# CITY OF ALBUQUERQUE

**Re: Funnel Cake Building, 1622 2<sup>nd</sup> Street NW, Grading and Drainage Plan  
Engineer's Stamp dated 9-14-04 (J14-D151)**

Based upon the information provided in your submittal received 9-14-04, the above referenced plan cannot be approved for Building Permit until the following comments are addressed:

TITLE: **SITE/ UTILITY PLAN AND HANDICAP RESTROOM DETAILS**

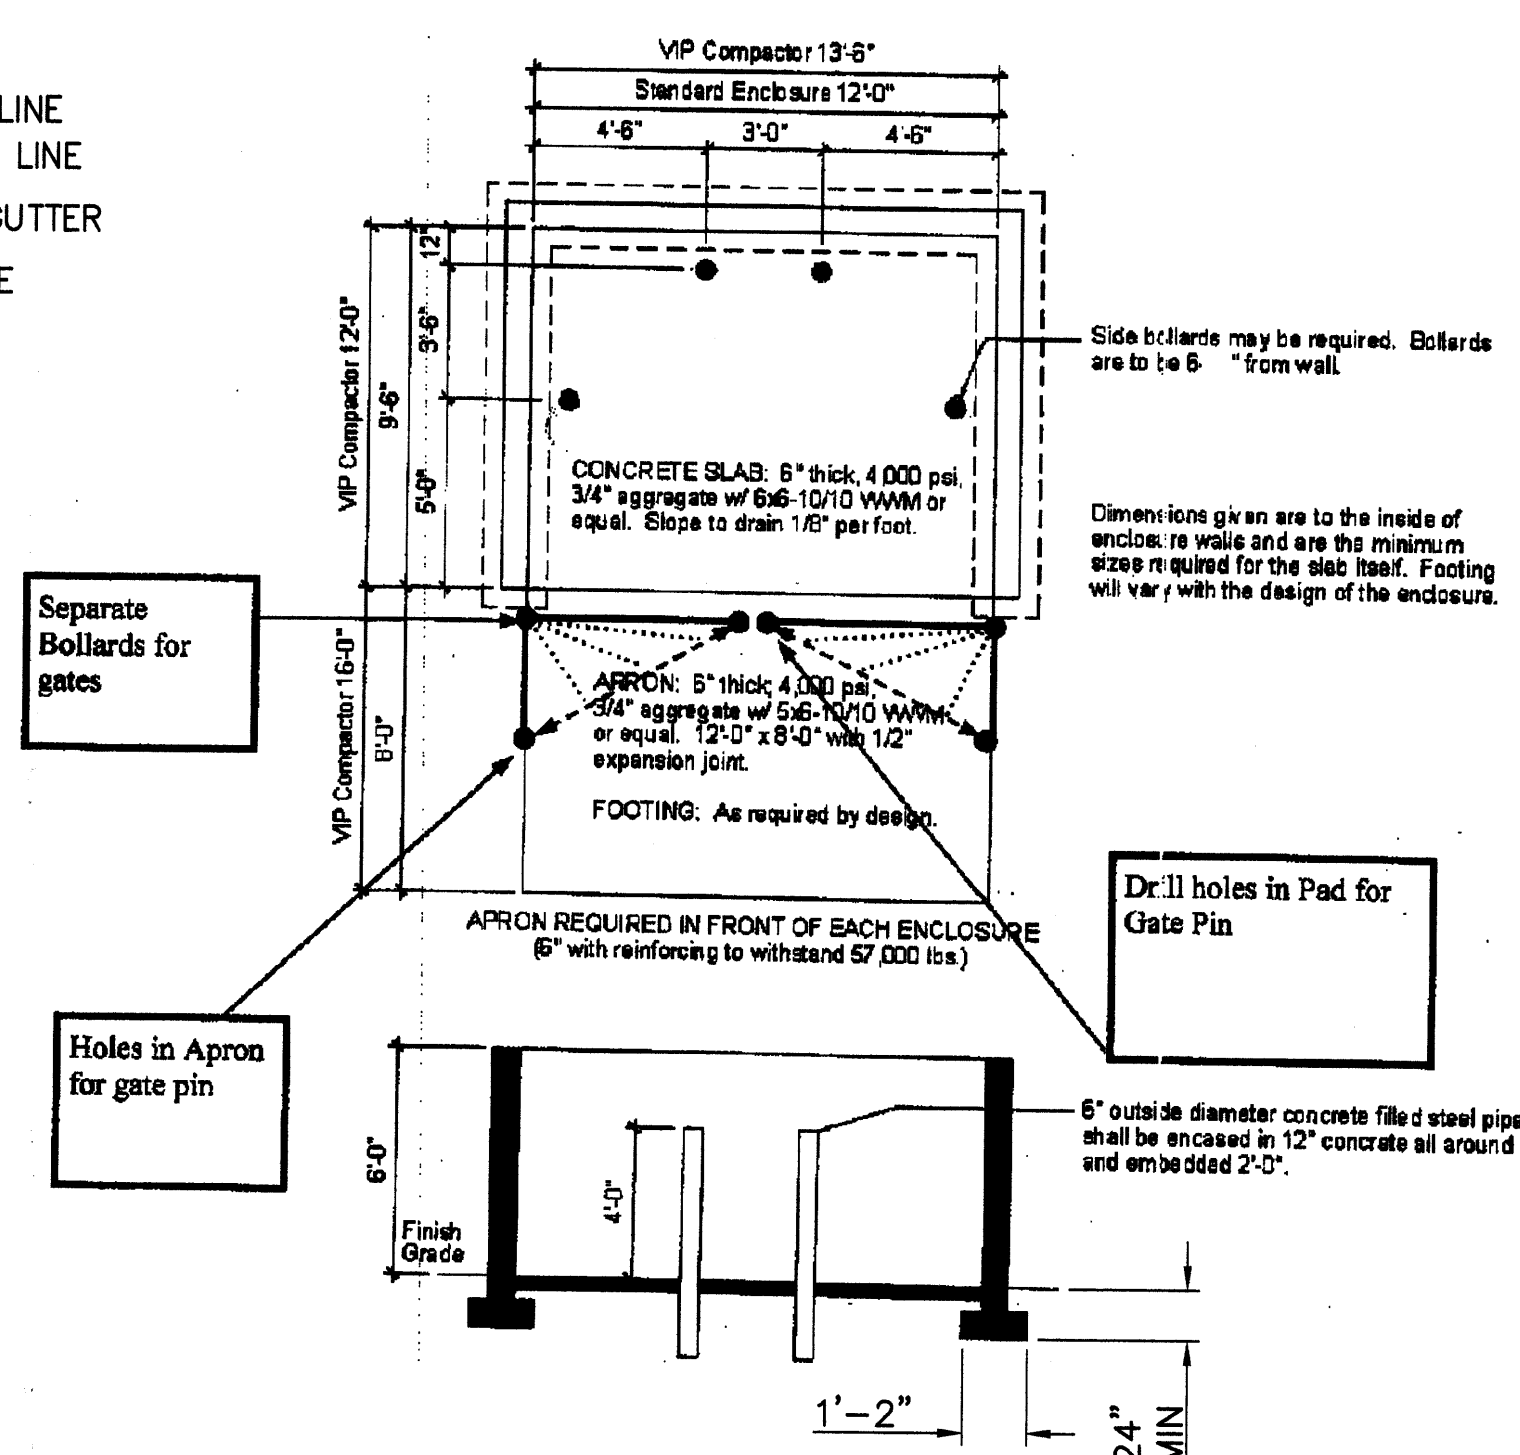
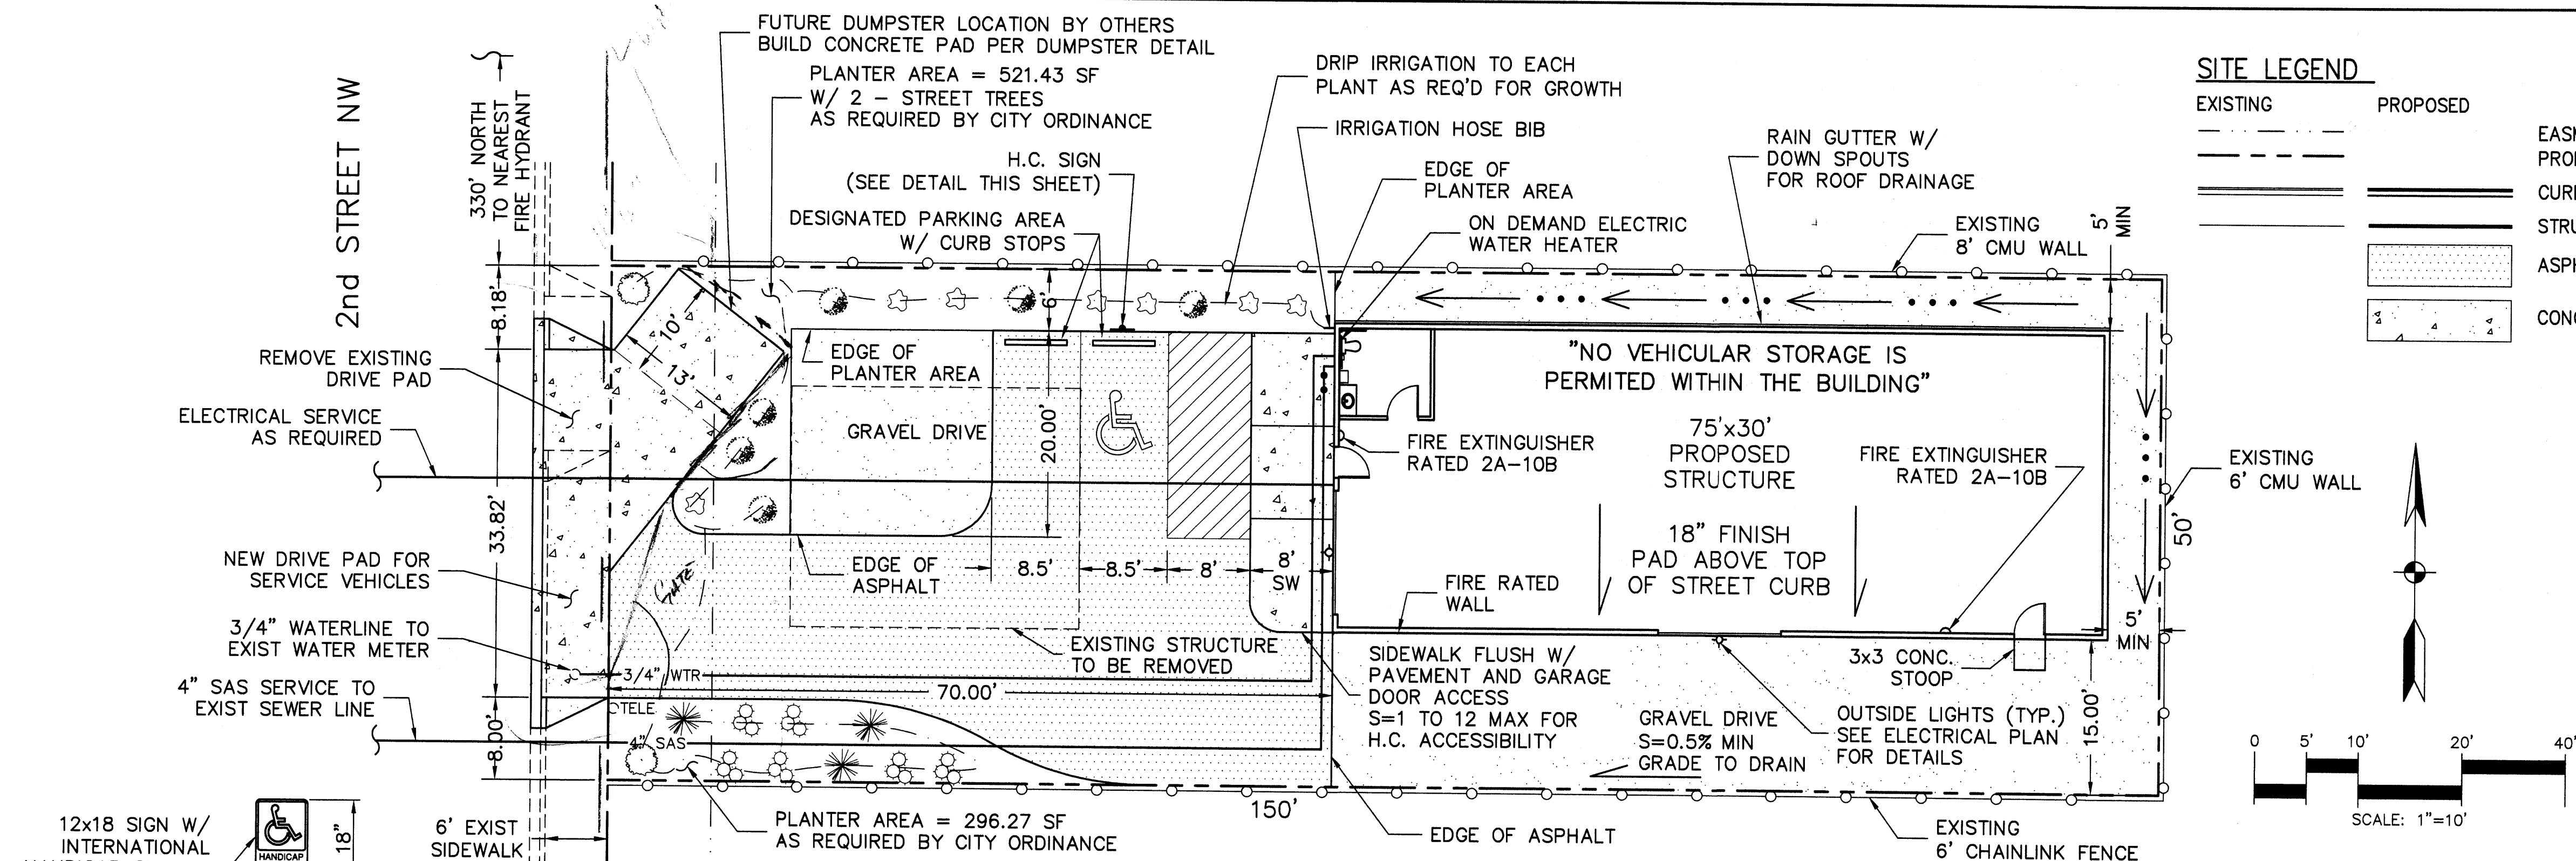
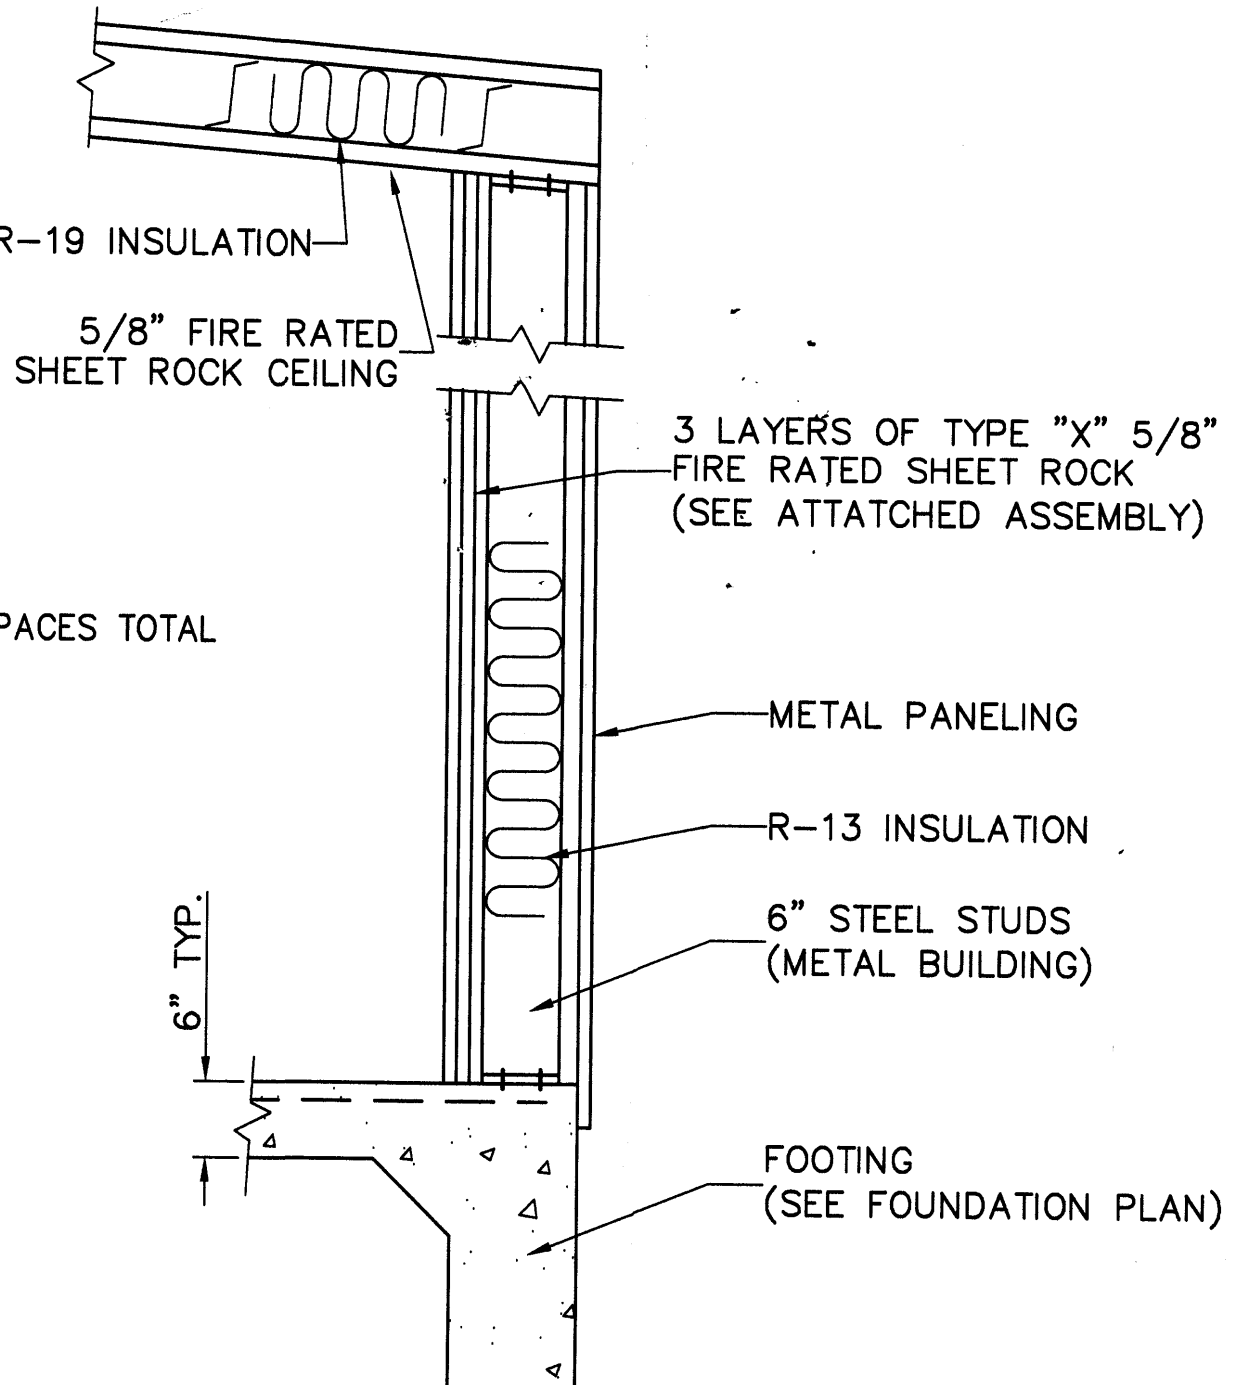
1. The check list shown in Chapter 22, Section 7 of the City of Albuquerque Development Process Manual requires existing and proposed contours to be shown. These contours can be given by contour lines or spot elevations. These elevations must extend a minimum of 25 feet past the site.
2. Address offsite flow.
3. Please provide a swale detail.
4. Define the proximity of the site to any flood hazard zones.
5. Provide a vicinity map.
6. Give both existing and proposed conditions of the site (flow direction, calculated flow vales, etc.).
7. What is the finished floor elevation of the warehouse?

No Elevations!

Swale Detail

What is currently on the site?

Does all flow drain to street?

Finish Floor Elevation
